Ryan Kanteres
SSA Architects
75 York St
Portland, ME 04101

Derek Converse, LEED AP BD+C
Director of Preconstruction and Estimating
Zachau Construction Inc.
1185 US Route One // PO Box J // Freeport, ME 04032

March 15, 2016

LIFESAFETY PLAN + CODE SUMMARY

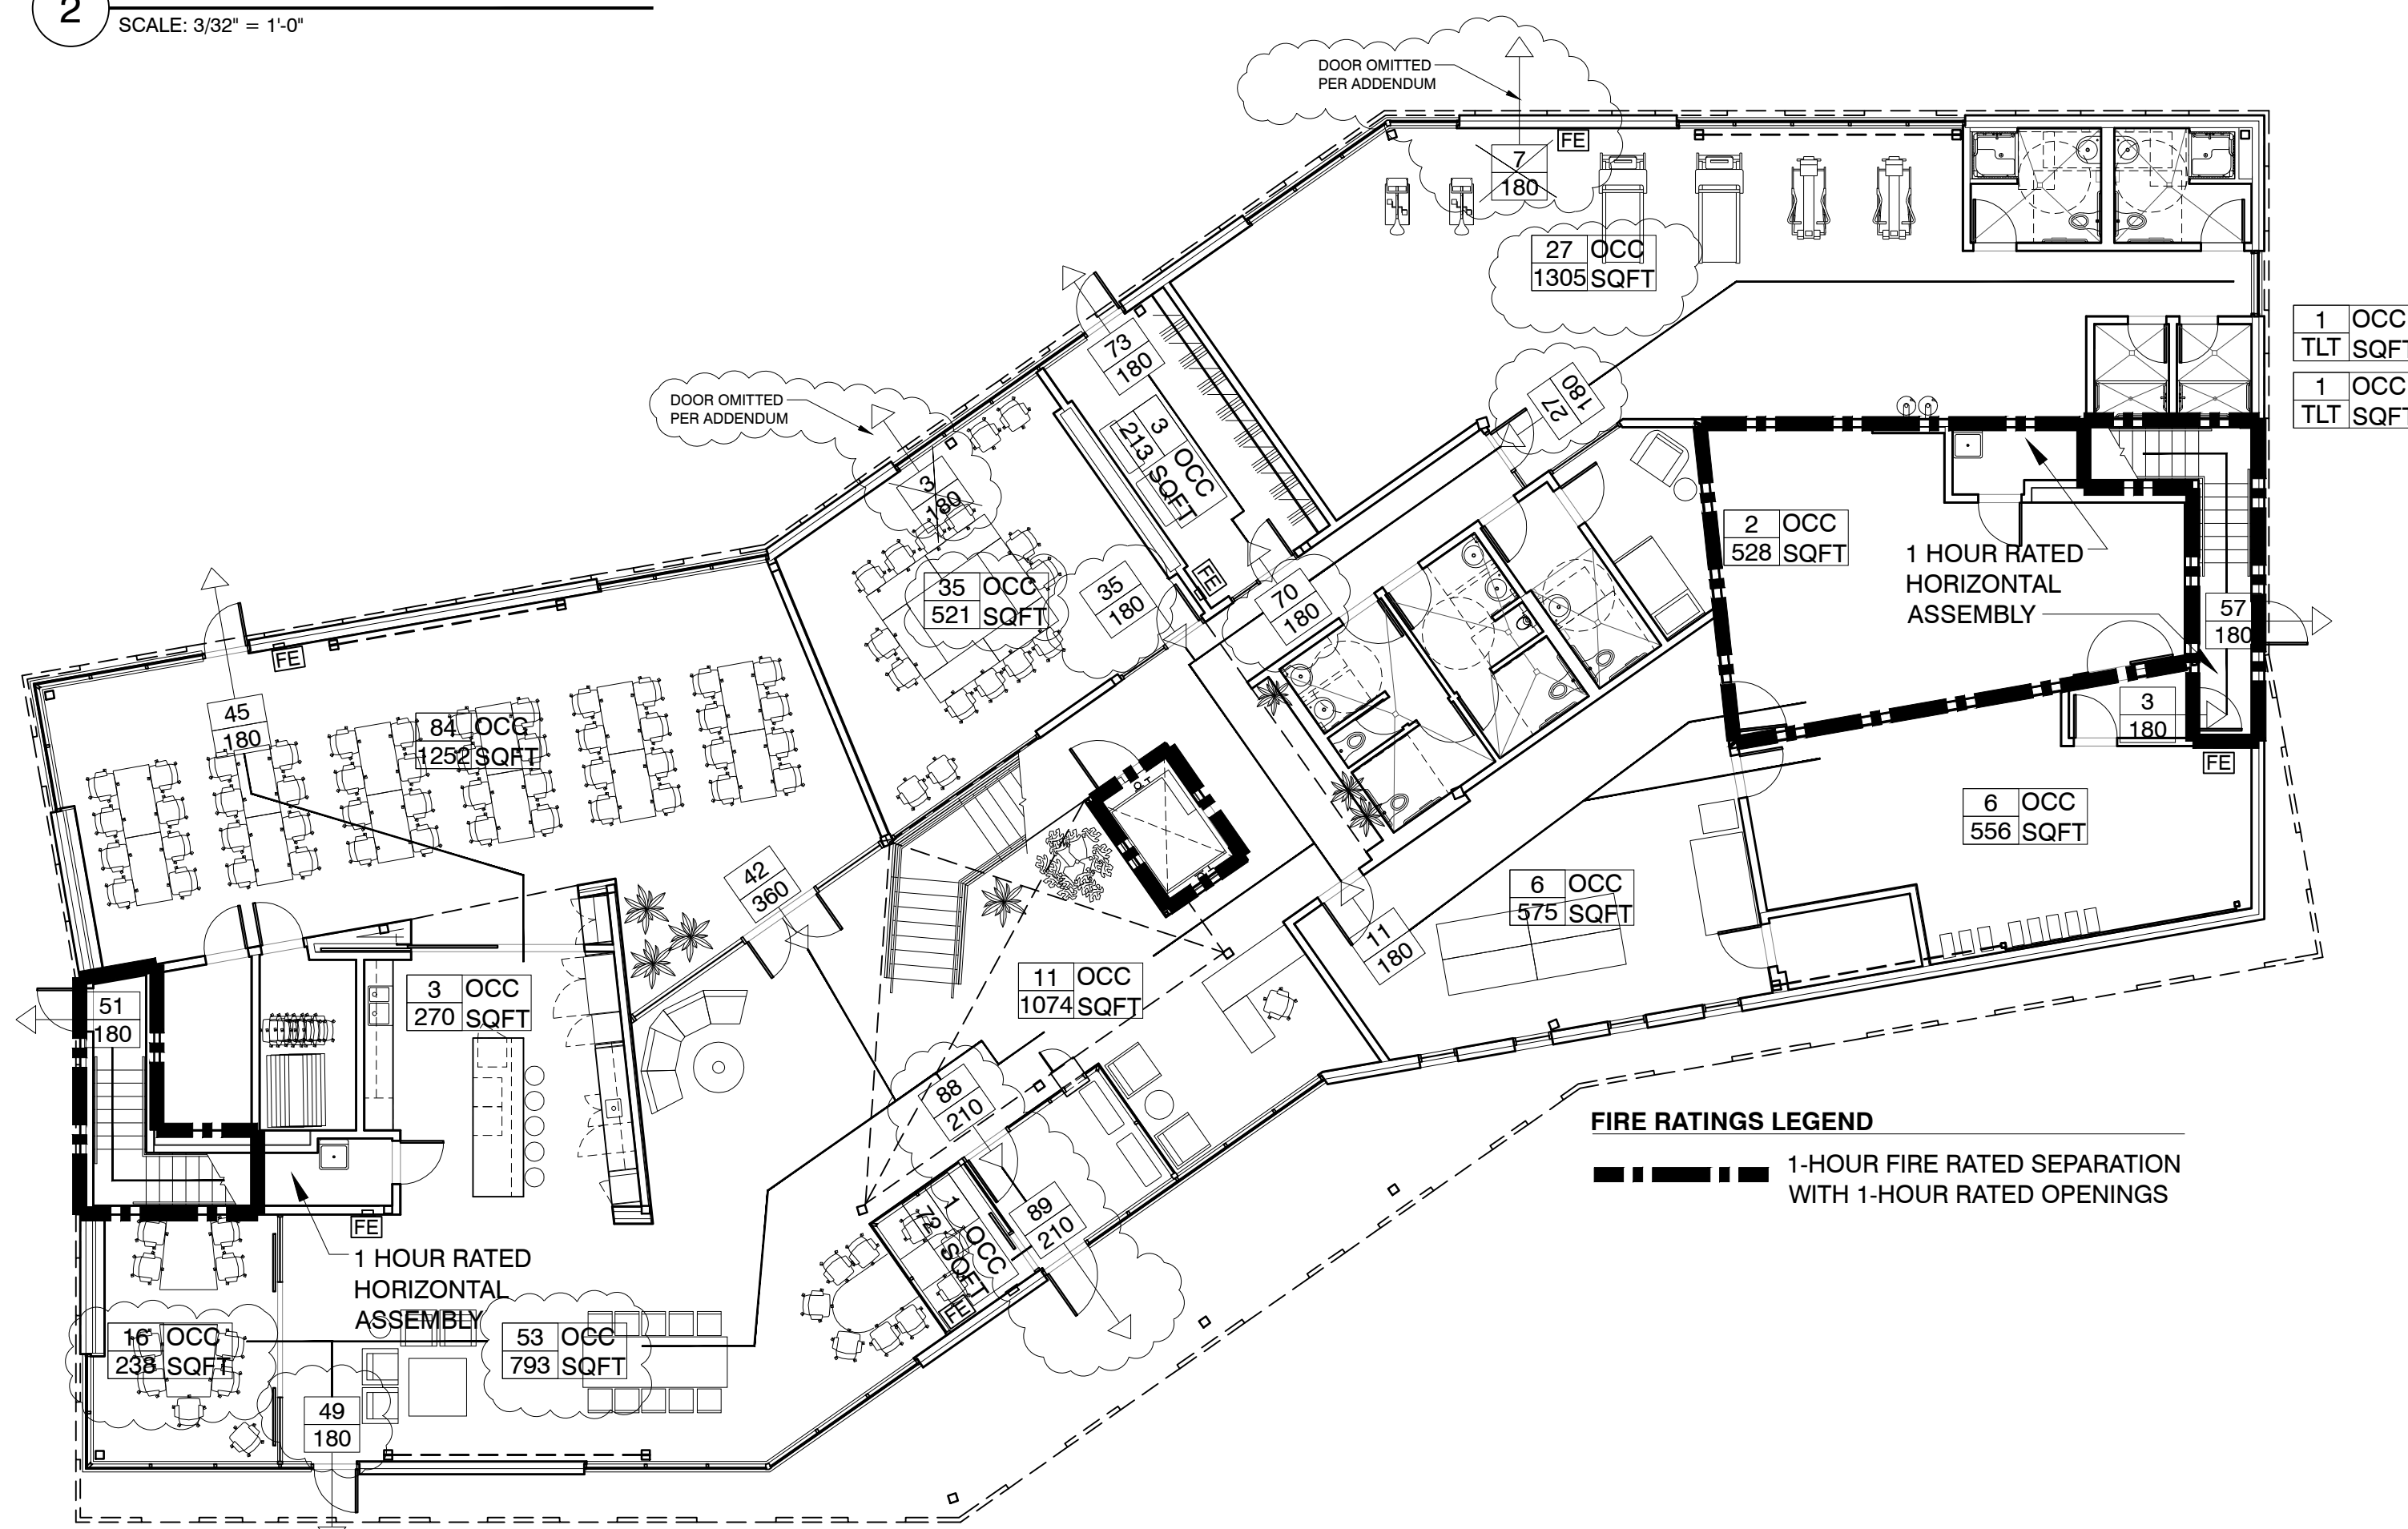
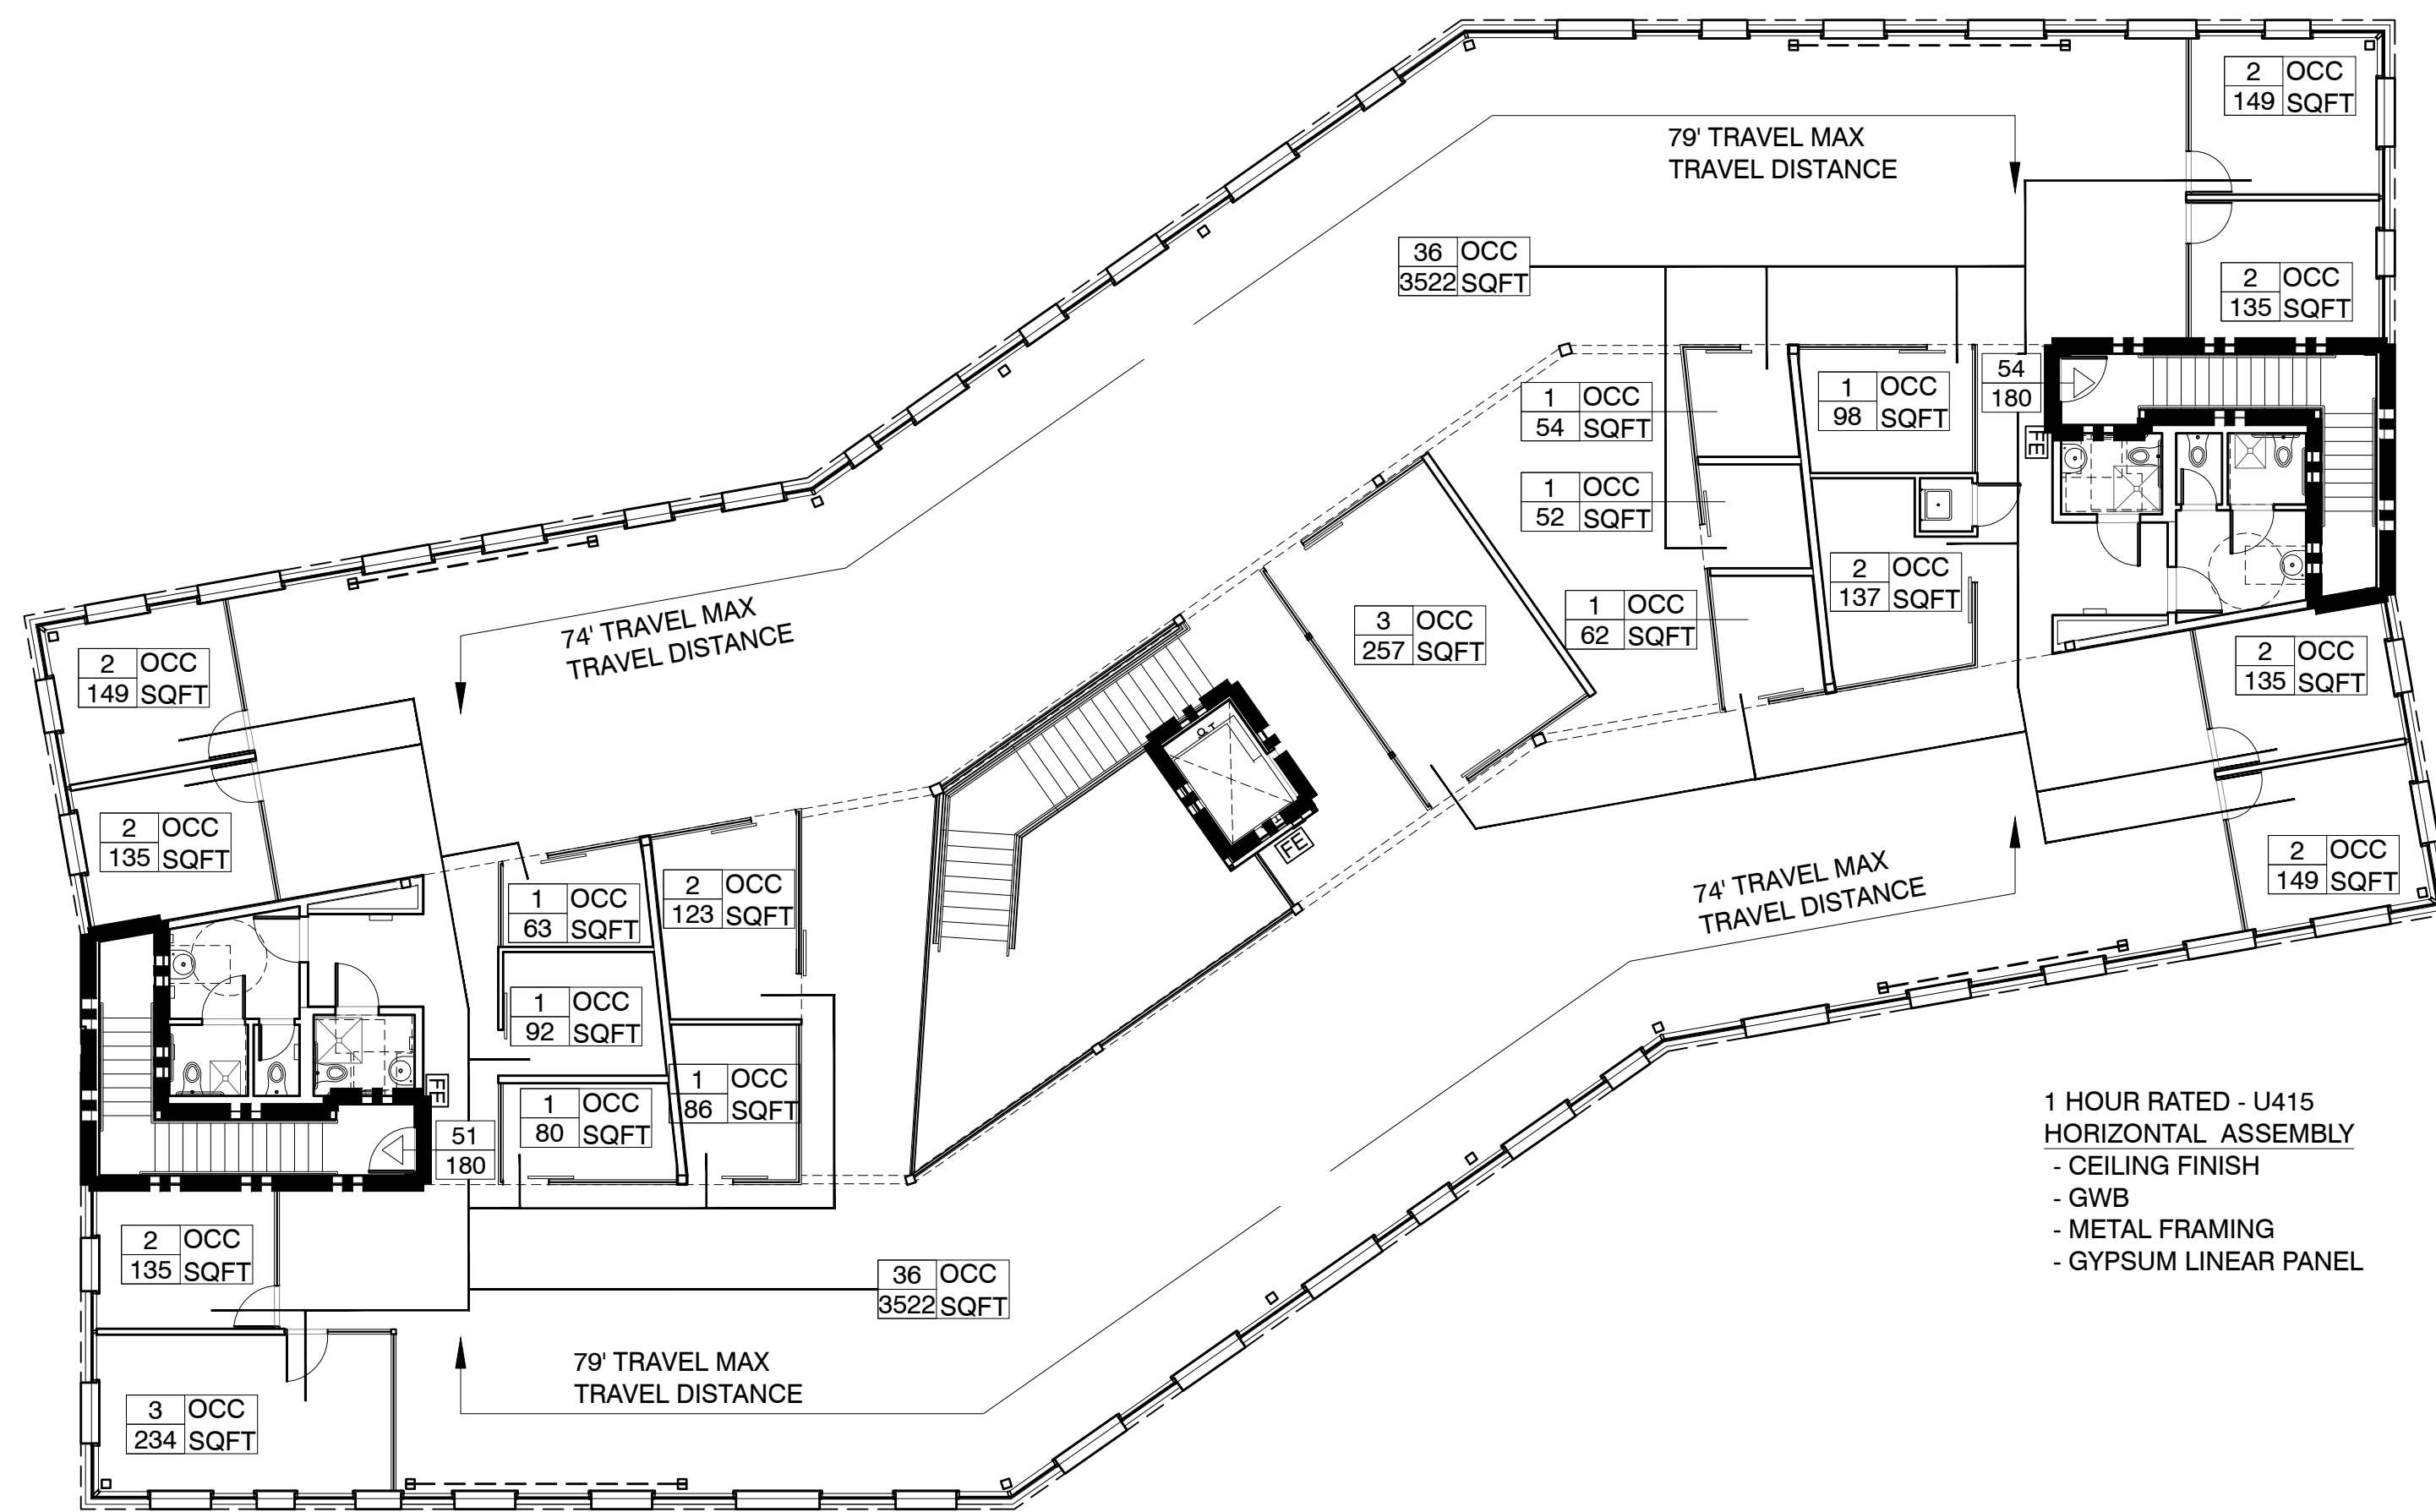
We have prepared the attached documents to respond to the concerns raised on the plan mark ups we received earlier, as well as to submit updates from client initiated addendum. Per the client's security request we have eliminated two exterior doors. These doors were previously utilized for supplemental egress, but we feel that the building is able to accommodate egress requirements without these doors.

We are including a fully updated G002 Life safety plan + Code summary, to address these changes and respond to comments about the calculated occupancy, exit access, and plumbing fixtures. While we have supplemented documentation our interpretation is still that the central stair opening is a permitted convenience opening rather than an atrium. We have also attached the requested ComCheck documentation, furniture plans, and supplemental information on the finishes.
